2022/0902

Alterations to existing car park consisting of resurfacing works, car park space and road markings and entrance and exit barrier

Barnsley Gist Ltd, Carlton Industrial Estate, Industry Road, Barnsley, S71 3LJ

DRAWING:
DRAINAGE WORKS

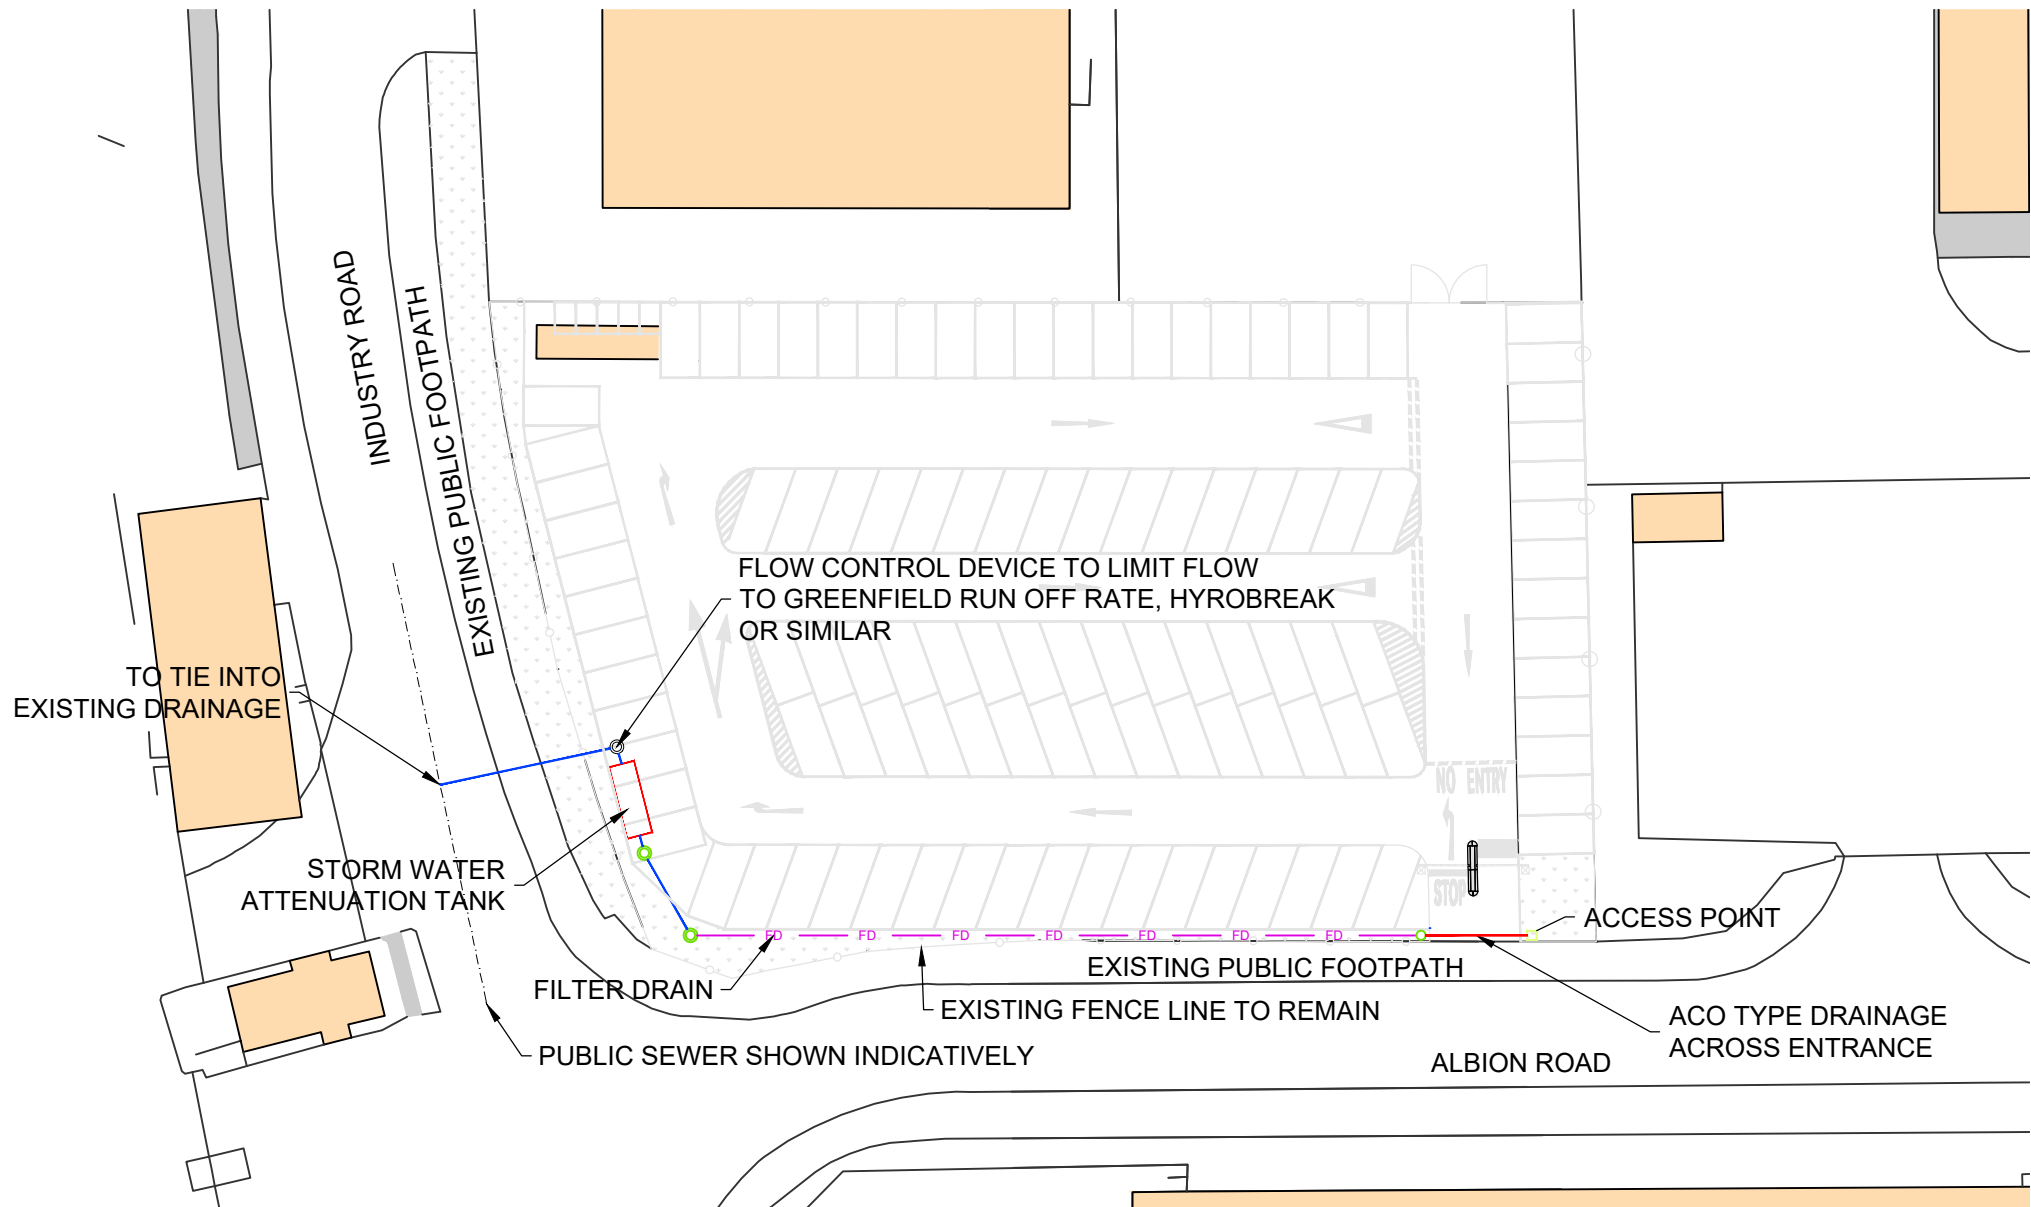
Drainage – (comments on amended plans): There are outline drainage details shown on the plans, with the application form describing surface water to Suds or Mains if the Permeable Paving proposal is unsuitable, I note that the area is well served by sewers, I consider that a conditional approval is appropriate in this case.

H4 - No development shall take place unless full surface water drainage details, including Yorkshire Water Permission to discharge, have been submitted to and approved in writing by the Local Planning Authority. Thereafter no part of the development shall be occupied or brought into use until the approved scheme has been fully implemented. The scheme shall be retained throughout the life of the development unless otherwise agreed in writing with the Local Planning Authority. @ To ensure the proper drainage of the area

The proposal indicates an intention to allow water to continue to drain into the site, or if that is not possible, to drain the site via an attenuation tank to the sewer. A condition is recommended based on the advice of the drainage engineer to require full surface water drainage details to be agreed and implemented.

BOUNDARY WORKS
SCALE 1:500

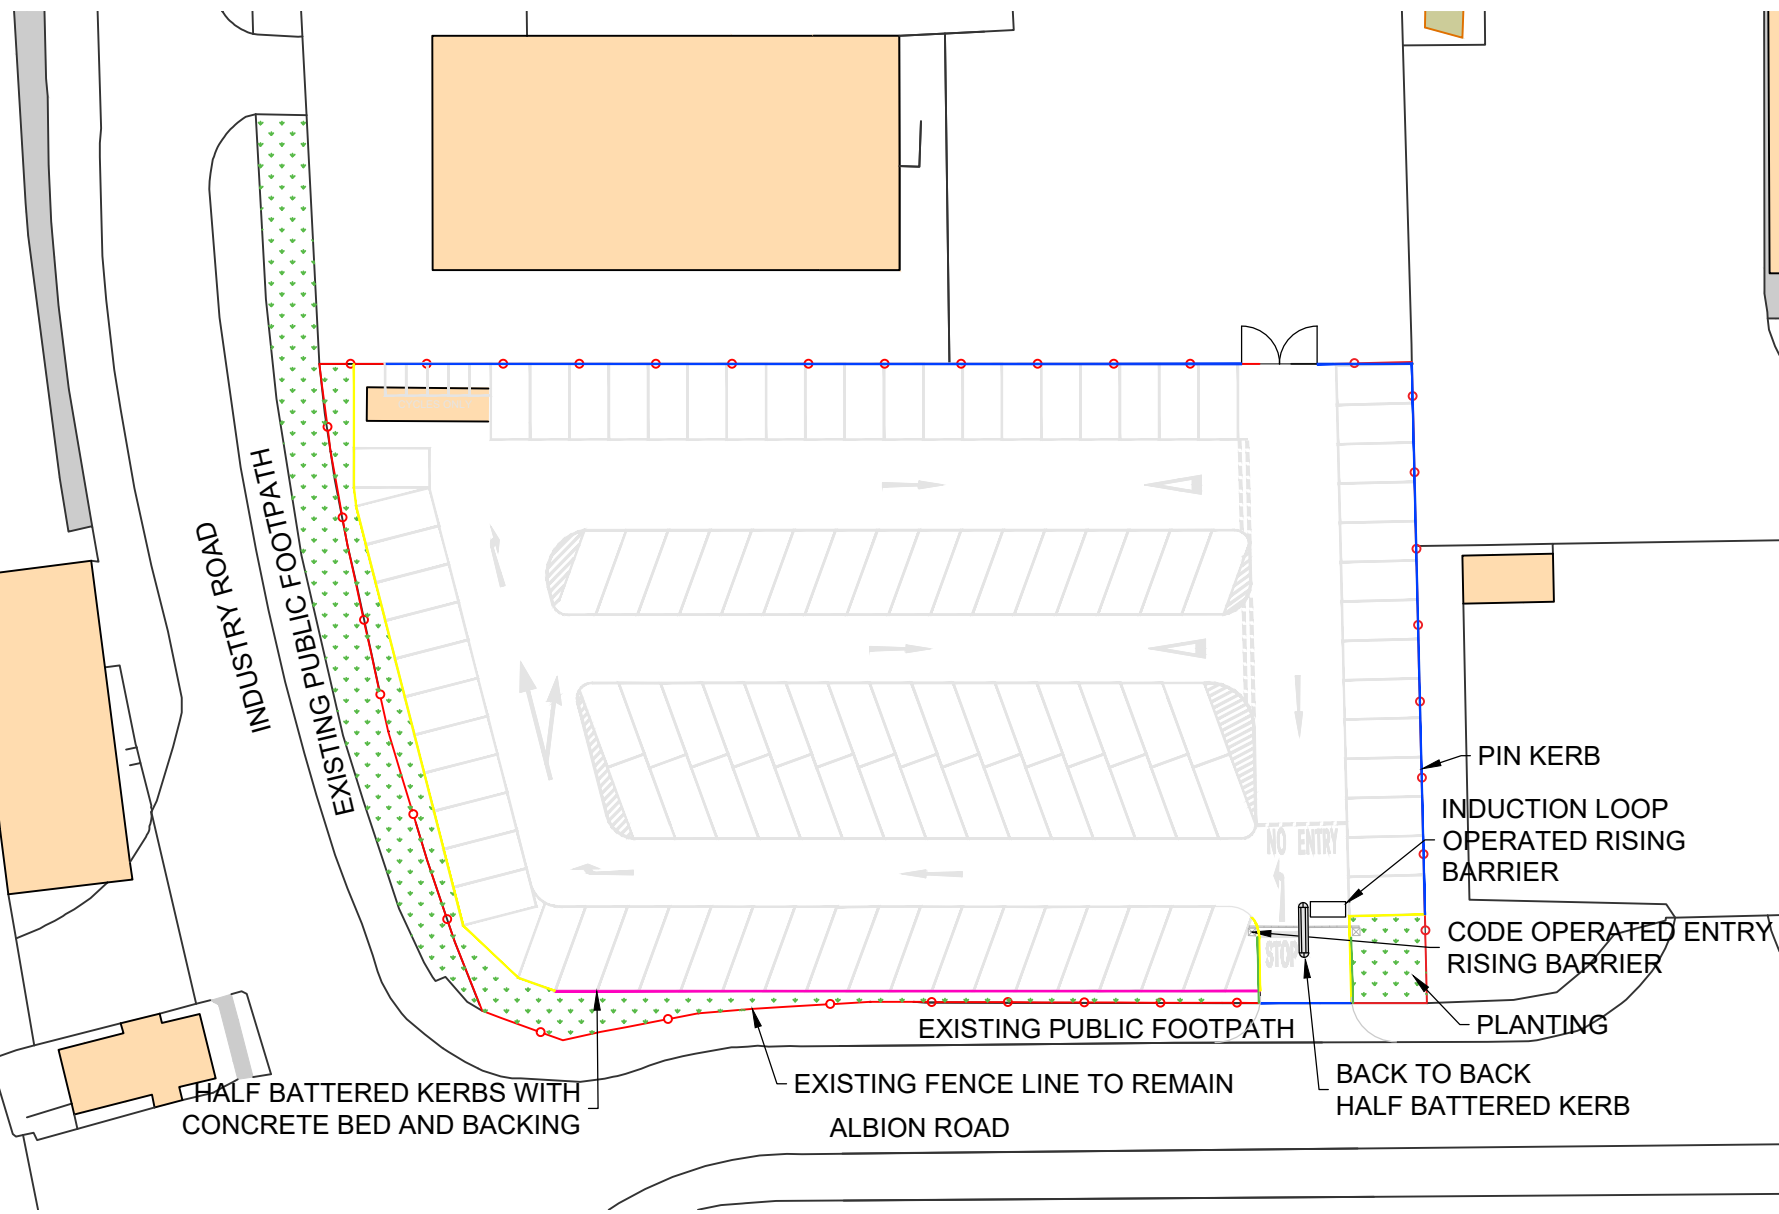
Highways DC - (comments on amended plans) The proposed entry barrier has now been moved to a position 5m into the site which will allow vehicles to pull clear of the public highway when pulling up to the barrier to enter the site. The proposals are therefore considered acceptable from a highways point of view, should you be minded to grant permission I would be grateful if you could include the following conditions:

Any gates or barriers at the vehicular access shall be set back a minimum distance of 5m from the back of footway, be designed to open inwards or upwards and permanently retained as such for the lifetime of the development. Reason: To ensure vehicles are able to pull clear of the adopted highway and avoid becoming an obstruction to approaching / oncoming traffic.

The proposed asphalt finish will improve the appearance of the site. There are no detailed drawings of the proposed barriers and the small sections of additional fencing to define the 5 metre set back of the barriers. A condition is recommended to require the details to be agreed.

The proposed surfacing and delineation will secure a safe and appropriate car park layout for 108 cars. An existing bike shed is to be retained. The proposed barriers have been moved to 5 metres from the back edge of the footway and it is concluded that the proposals are acceptable from a highway safety point of view subject to conditions requiring the surfacing of the car park, the provision of drainage to prevent the discharge of surface water on to the highway, to secure the 5m set back of the barriers from the highway and to require the retention of the bike shed for cycle parking.

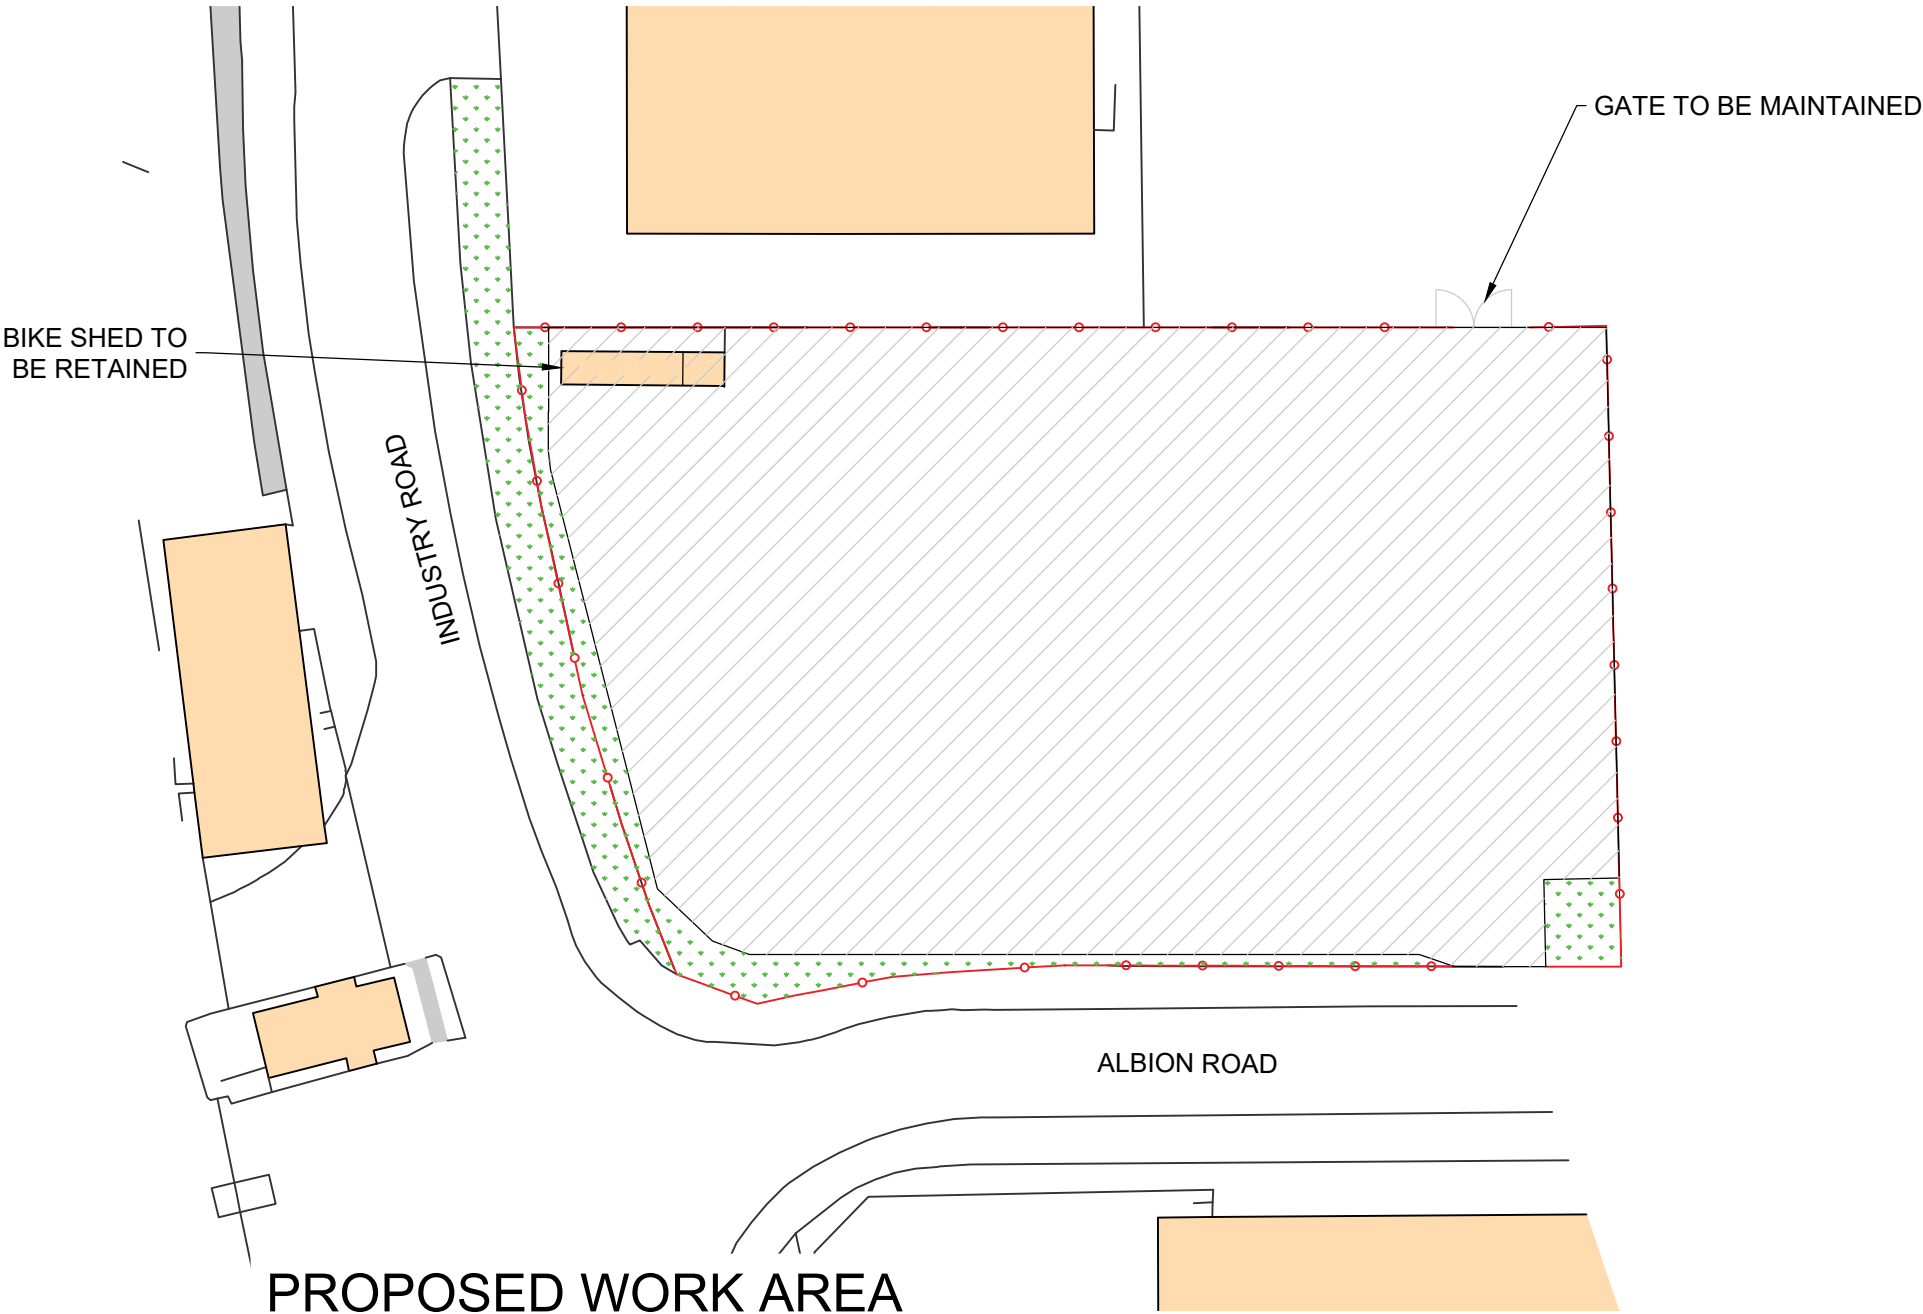
The resurfacing is proposed to upgrade the car park. Permeable asphalt is proposed to allow continued ground absorbing drainage. The application notes that in the event that permanent asphalt is not technically possible storm water attenuation will be designed to allow storm water drainage to the public sewer (subject to Water Authority approval)

The parking facilities as indicated on the submitted plan shall be surfaced in a solid bound material (i.e. not loose chippings) and adequate measures shall be so designed into the car park to avoid the discharge of surface water from the site on to the highway.
